From: [Melissa Rassack](#)
To: [Shaun Williams](#)
Cc: [Alex Rudd](#); [William Hodgkinson](#); [David Burge](#); [Alejandro Trevino](#)
Subject: FW: Kemps Creek Data Centre - Request for Input in Planning Secretary's Environmental Assessment Requirements (SEARs)
Date: Thursday, 5 November 2020 1:05:09 PM
Attachments: [20201103 - UD COMMENTS - Kemps Creek Data Centre .pptx](#)

Thank you for the opportunity to comment. As you are aware, in June this year, the Mamre Road Precinct was zoned for Industrial purposes and the Structure Plan for the Precinct was approved. We are currently working on the draft Development Control Plan (DCP) for the Precinct with the aim of exhibiting shortly. The DCP will provide detailed design controls for development in the precinct in line with the approved Structure Plan.

The Department of Planning and Environment has received a request for Planning Secretary's Environmental Assessment Requirements (SEARs) for the Kemps Creek Data Centre (SSD-1010987) in the Penrith local government area. The proposed development is a State Significant Development under the Environmental Planning and Assessment Act 1979.

Checked By DW	Project Status SUBMISSION	
									Approved By AO	Drawing Title SITE PLAN	
									Scale 1 : 2000 @ A0	Drawing Number A010	Issue 2

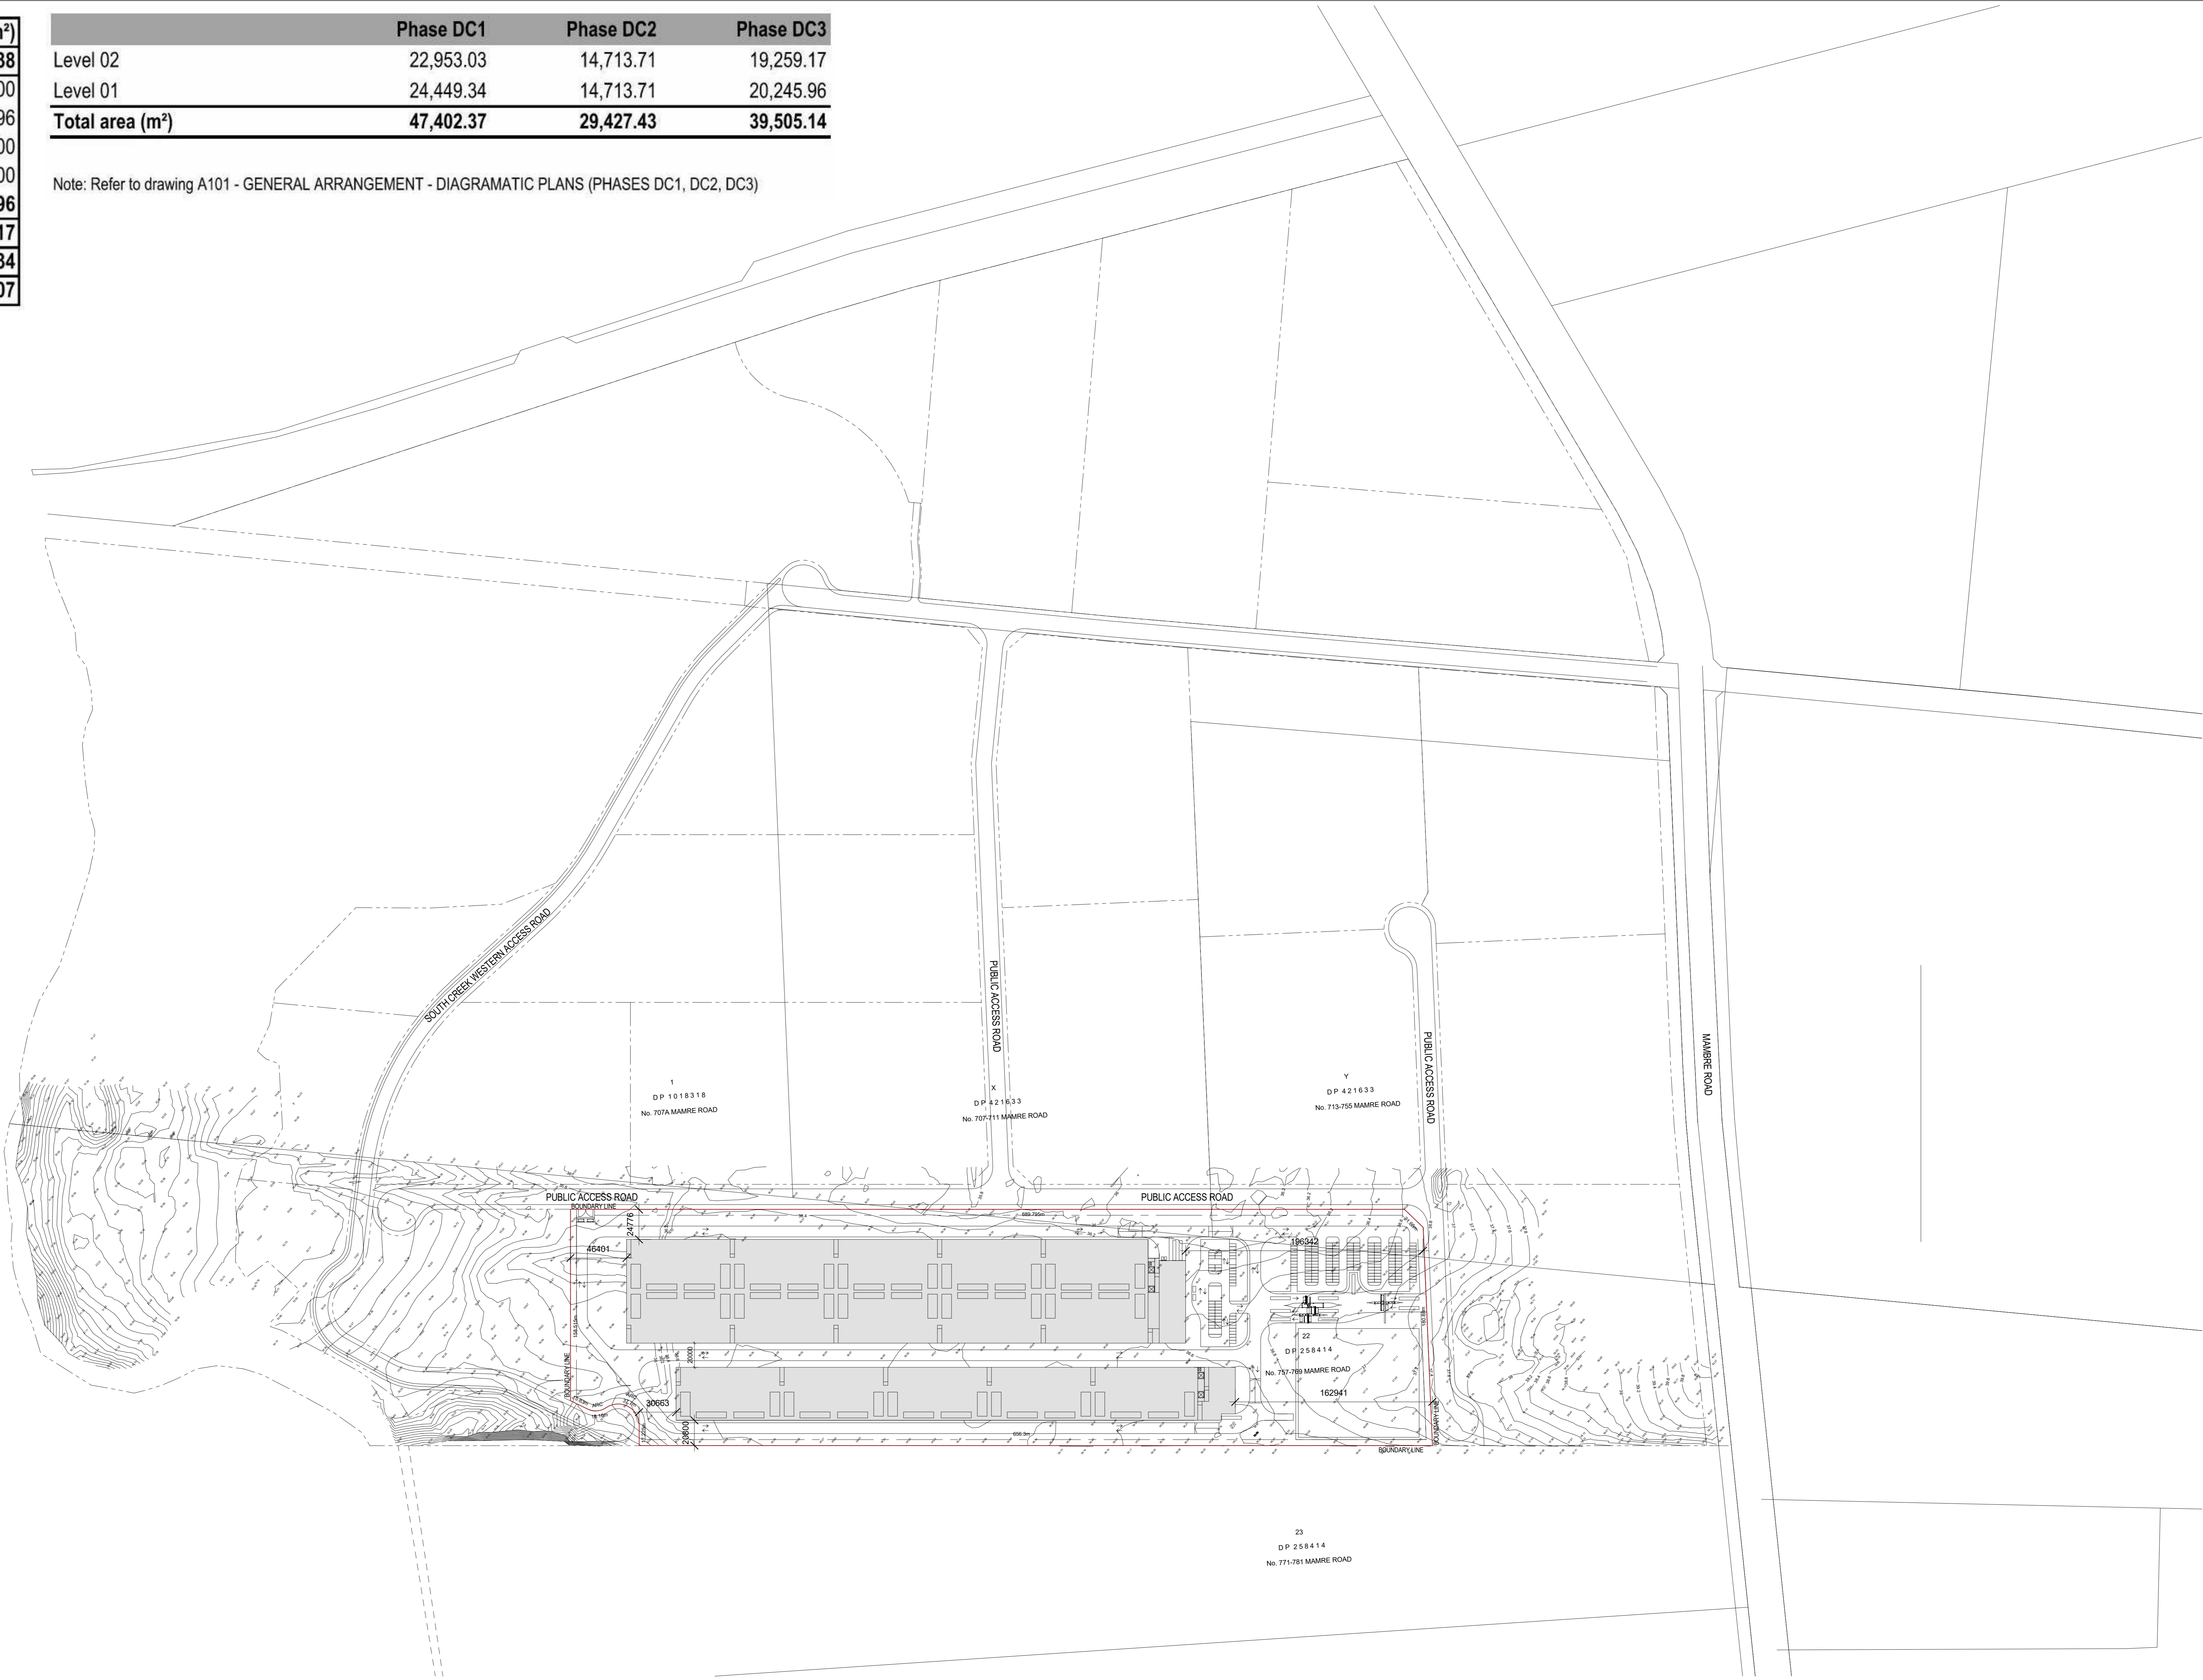
- The SSD will need to address:
 - Sensitive landscape design of the interface with the RE1 zoning on the site, potential RE1 road, the adjacent bio-basin to the west and the southern boundaries.

- Road networks and design, including access locations. As identified in SSD 9522, the north-south road is a potential Distributer Road under the indicative precinct road network. Distributer Roads are proposed to be accessed denied. Where an alternative site access can be accommodated, the design should be amended to provide this alternative.
